Scale 1" = 20'
Contour Interval: 1'

DRAWN BY: D.E. WATTS DATE: 4-2-21 DWG. NO.: 20-5509-06 SURVEYED BY: DEW, ESW, 6-26-19, 9-24-20	APPROVED BY: PROJ. NO.: DWG.:	REVISIONS 9-27-21 REVISED PER COUNTY REVIEW COMMENTS DEW 12-30-21 REVISED PER COUNTY REVIEW COMMENTS DEW 1-13-22 REVISED CURB TYPE AS REQUESTED DEW	OLIVER E. WATTS CONSULTING ENGINEER COLORADO SPRINGS	PROJECT 10659 MALTESE POINT LOT 11, ROLLING THUNDER BUSINESS PARK EL PASO COUNTY	SHEET NAME GRADING AND EROSION CONTROL PLAN	SHEET NO. 1 OF 2
---	-------------------------------------	--	--	---	---	---------------------

PCD FILE NO. PPR-21-024

DRAWN BY: O.E. WATTS	APPROVED BY:	REVISIONS 3-16-21 REVISED BUILDINGS DEW	PROJECT 10659 MALTESE POINT LOT 11, ROLLING THUNDER BUSINESS PARK EL PASO COUNTY	SHT. NO. 2 OF 2
DATE: 4-2-21	PROJ. NO.	9-27-21 REVISED PER COUNTY REVIEW COMMENTS DEW		
DWG. NO.: 20-5509-07	DWG.	12-30-21 REVISED PER COUNTY REVIEW COMMENTS DEW		
SURVEYED BY: DEW, ESW, 6-26-19, 9-24-20				
OLIVER E. WATTS CONSULTING ENGINEER COLORADO SPRINGS			GRADING AND EROSION CONTROL PLAN

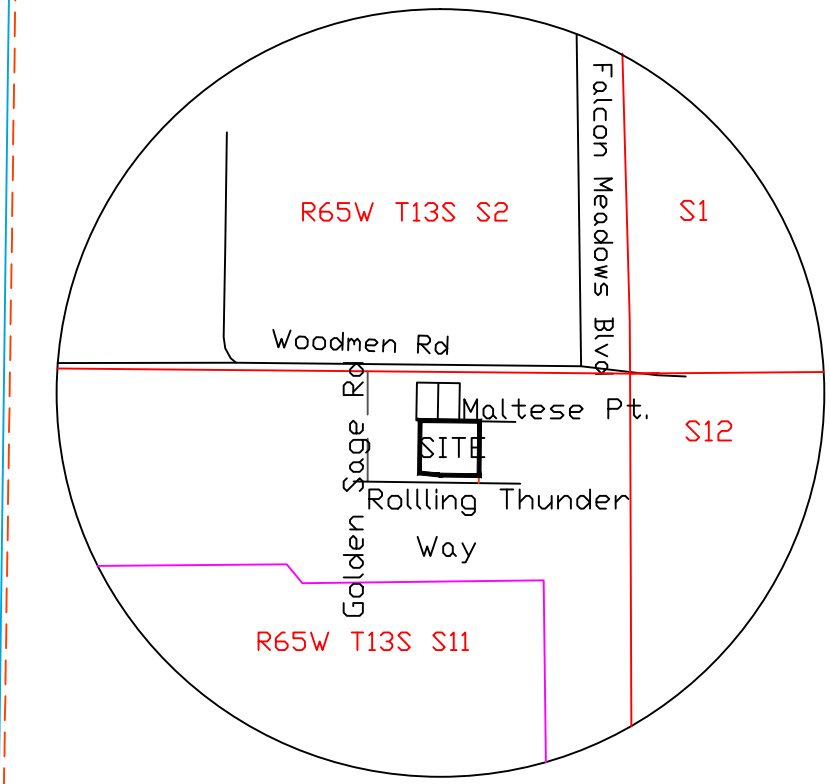
GEC Checklist Item p. the limits of cut and the limits of fill should be delineated for each, not the site limits for both combined. While the limits of disturbance can be the limit of fill, you are cutting at the pond area. Please show the limits of cut and the limits of fill and delineate between the two. Please call if you have any questions regarding this comment prior to resubmittal

How will the stormwater be diverted to the TSB and ultimately the SFB? The interim condition should have a diversion ditch directing the flow to the TSB. The final condition originally had two inlets and storm piping to the SFB, without this piping, its not clear how the stormwater will be directed to the SFB once the asphalt is installed. Please call if you have any questions regarding this comment prior to resubmittal

include inlet protection (interim) Unresolved

show pond details -- outlet structure, spill way, underdrain, etc. unresolved.

It appears that there may be a conflict with the proposed retaining wall and existing manhole and storm pipes. Please provide a detail/cross section showing how this will work or correct linework

The interim condition should have a diversion ditch to direct the stormwater to the TSB before the curb is installed. Please call if you have any questions regarding this comment prior to resubmittal
